Re: ABB Expansion; Traffic Impact Study Comment Response Letter

Thank you for the Traffic Impact Study review comments memo dated November 21, 2023 for the ABB Expansion project. The purpose of this letter is to provide responses to the comments to assist the City of Albuquerque with review of the traffic study.

FIGURE 11
ABB EXPANSION
ALBUQUERQUE, NEW MEXICO
RECOMMENDED GEOMETRY AND CONTROL

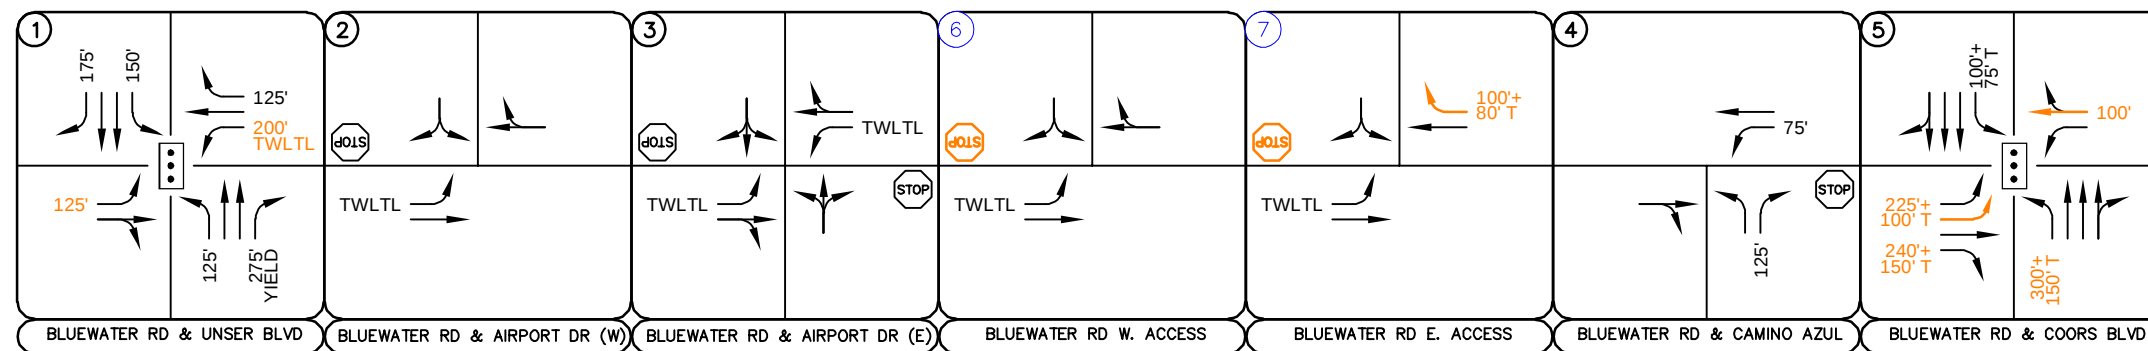
**Comment #3:** The Bluewater westbound approach to Unser left-turn lane should be extended.

**Response:** Extension of the westbound left turn lane at the Bluewater Road and Unser Boulevard is recommended in the current traffic study. This will only require a striping modification.

ABB EXPANSION
ALBUQUERQUE, NEW MEXICO
BLUEWATER RD & COORS BLVD PROPOSED STRIPING

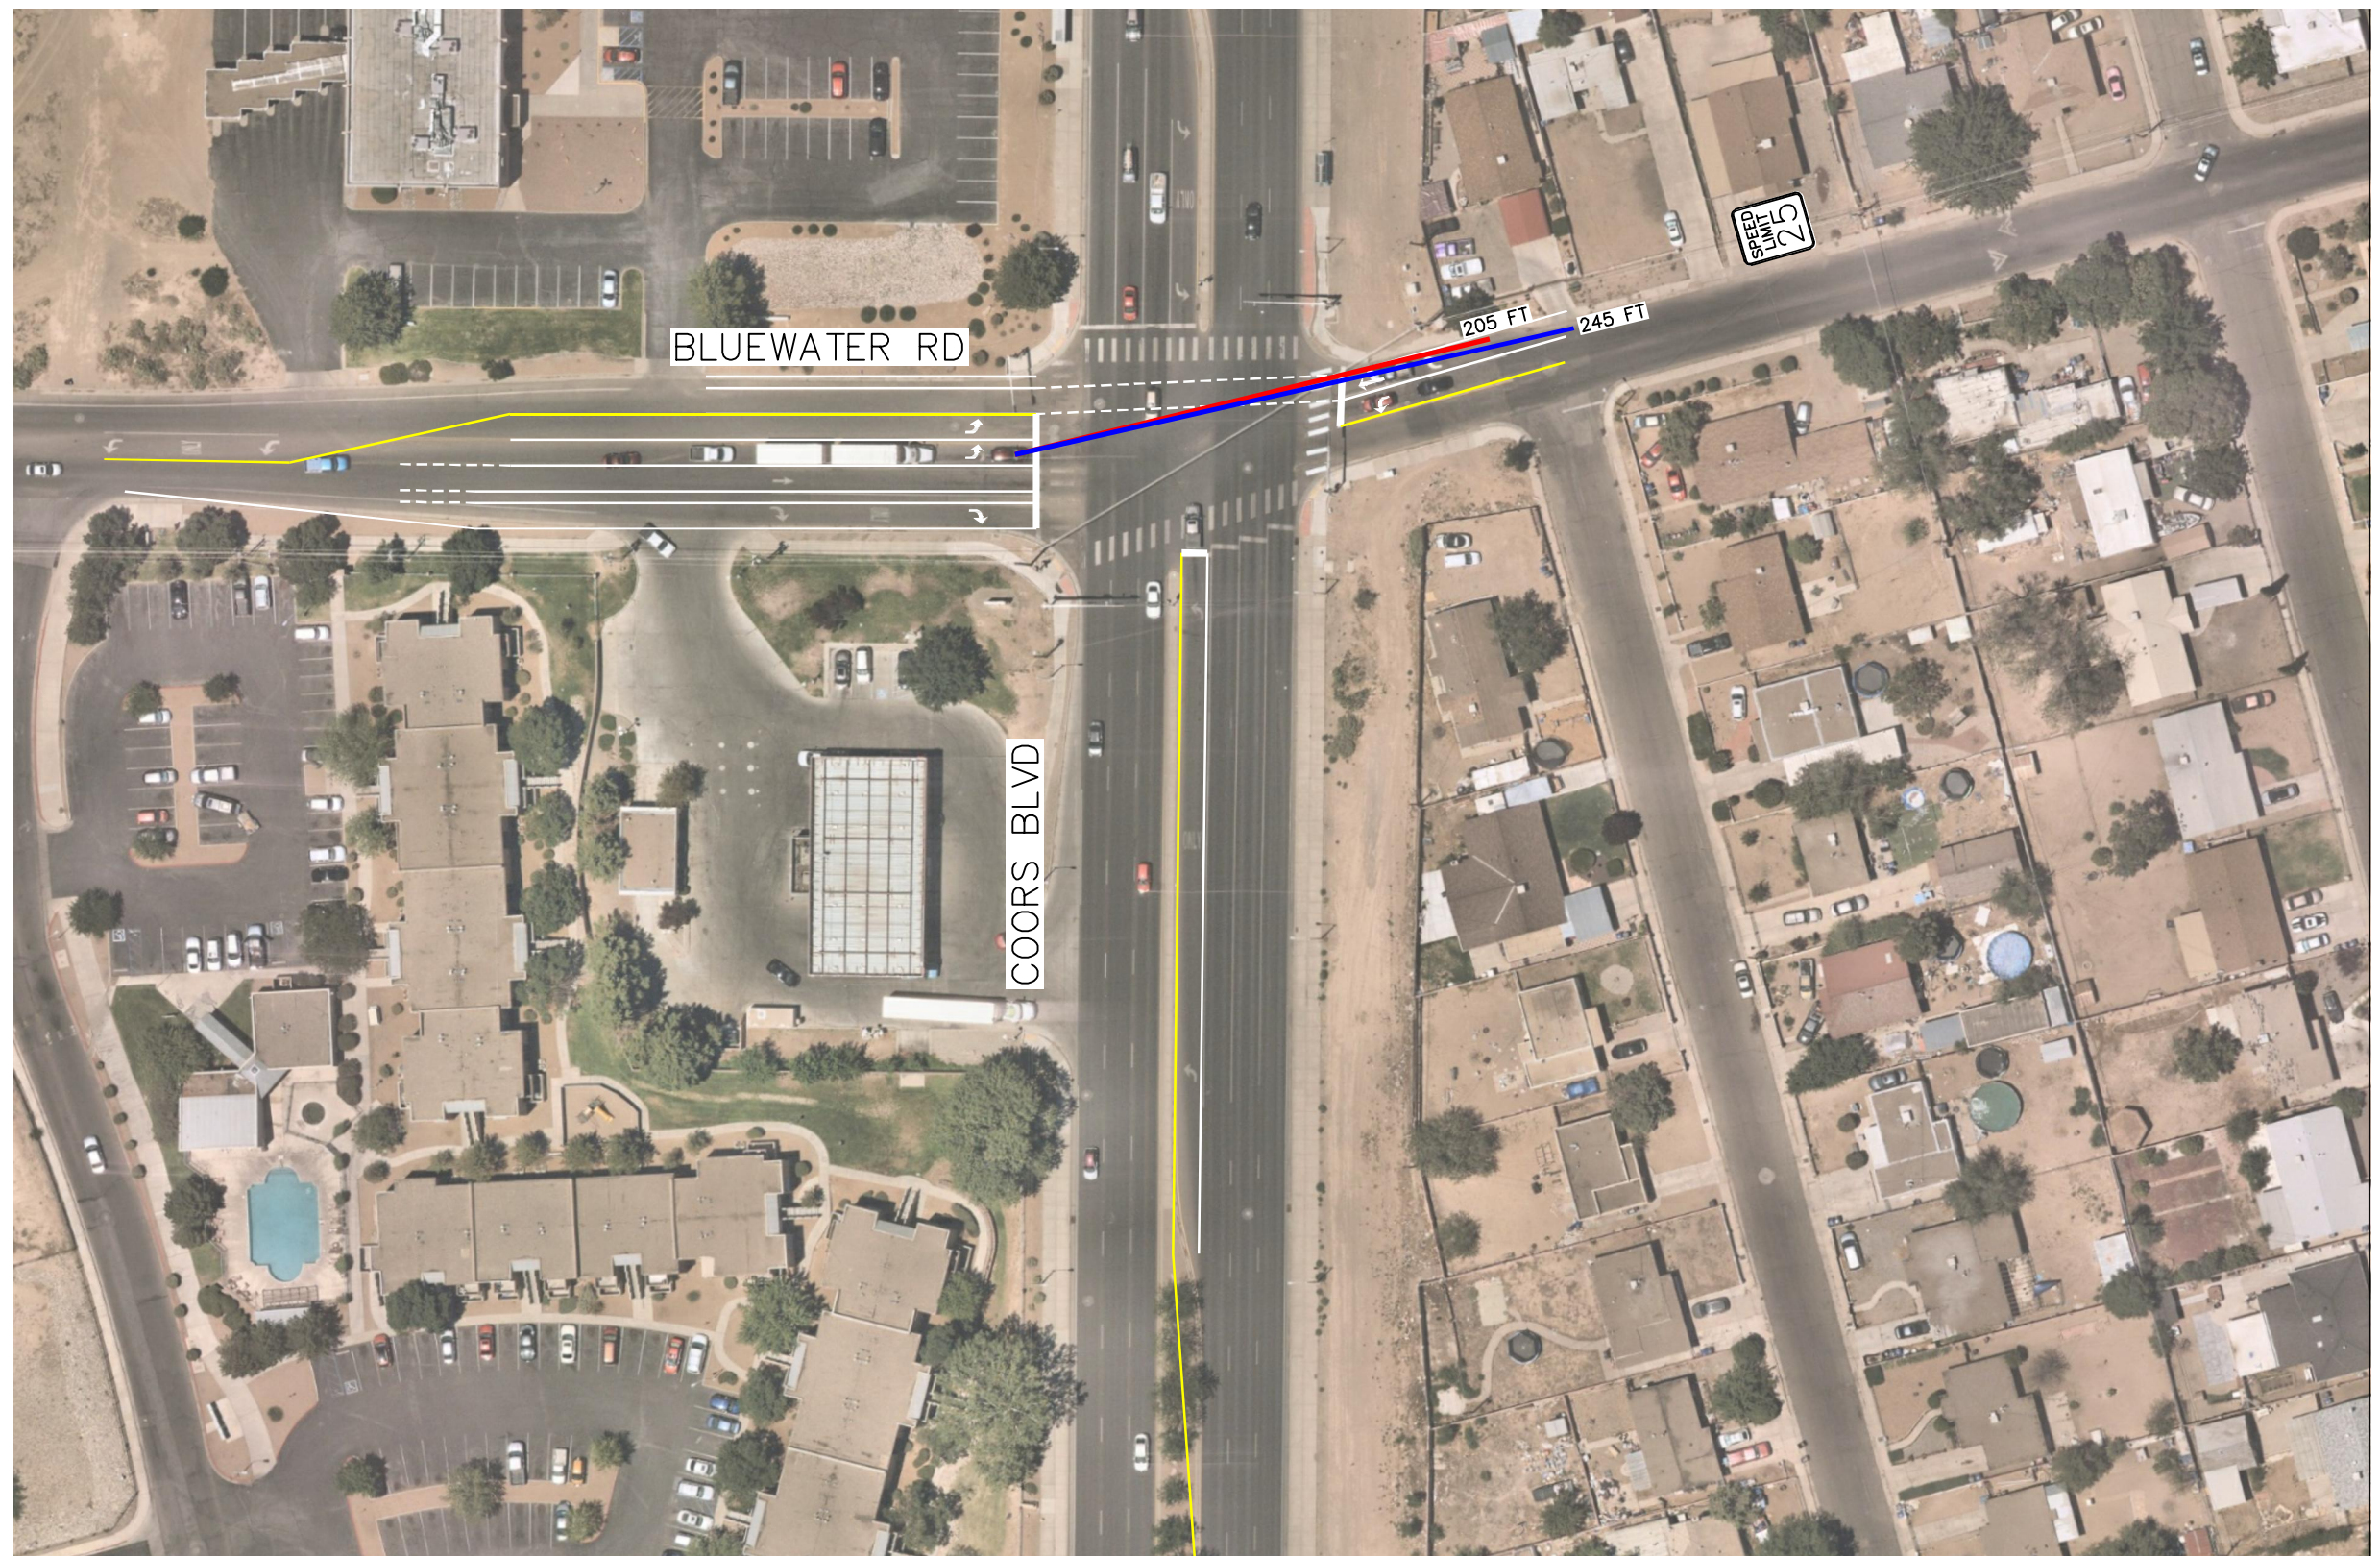
**Comment #2:** The eastbound right-turn lane on Bluewater approaching Coors Blvd. should be reconstructed extending and removing the taper transition to the turn-lane. The left-turn lane for this approach should be extended. The development contributes a small percentage to these movements. The future reconstruction, no project currently planned, of the right-turn lane will not be the responsibility of the development except any pavement striping/markings, and signs required due to the reconstruction. The City asks the developer to provide infrastructure improvements at their expense for the restriping and required signs for the existing right and left turn lanes.

**Response:** This will be a city planned project. However, the updated study shows the recommended turn lane length based on city standards.

FIGURE 7
ABB EXPANSION
ALBUQUERQUE, NEW MEXICO
2025 IMPLEMENTATION YEAR TOTAL TRAFFIC VOLUMES

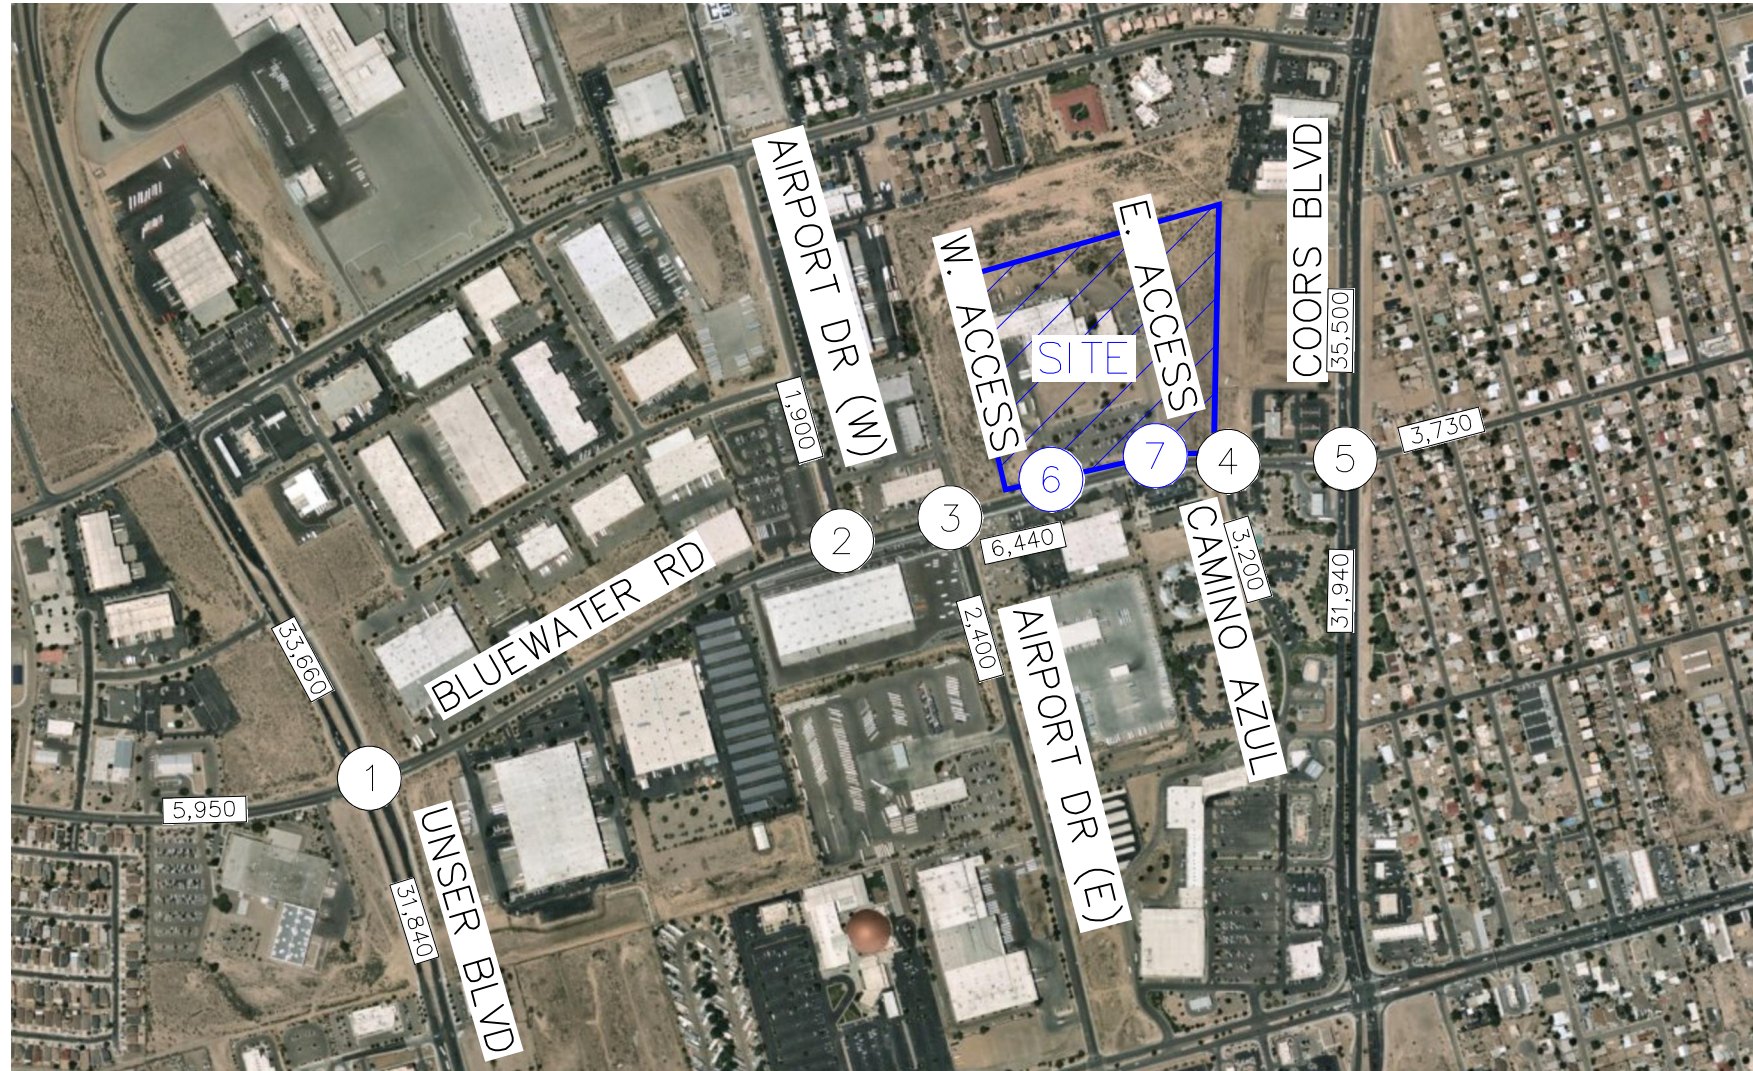
**Comment #1:** The 2025 Implementation Year AM peak hour traffic volume for the westbound right turn movement at the Bluewater East Access to the development traffic exceeds the City's warrant threshold for right turn lanes, see COA DPM Table 7.4.67 Turn Lane Warrants. Assess the available Right-of-Way for a westbound right turn lane at the East Access. Provide a recommendation for the right-turn lane geometry that will fit within the available ROW. The City is willing to accept a reduced length if the existing ROW is limited. A sidewalk easement may be required.

**Response:** The report was updated with a westbound right turn lane at the Bluewater Road East Access. This westbound right turn lane is recommended to be constructed to a maximum length of 100 feet with an 80-foot taper to fit within the existing ROW.
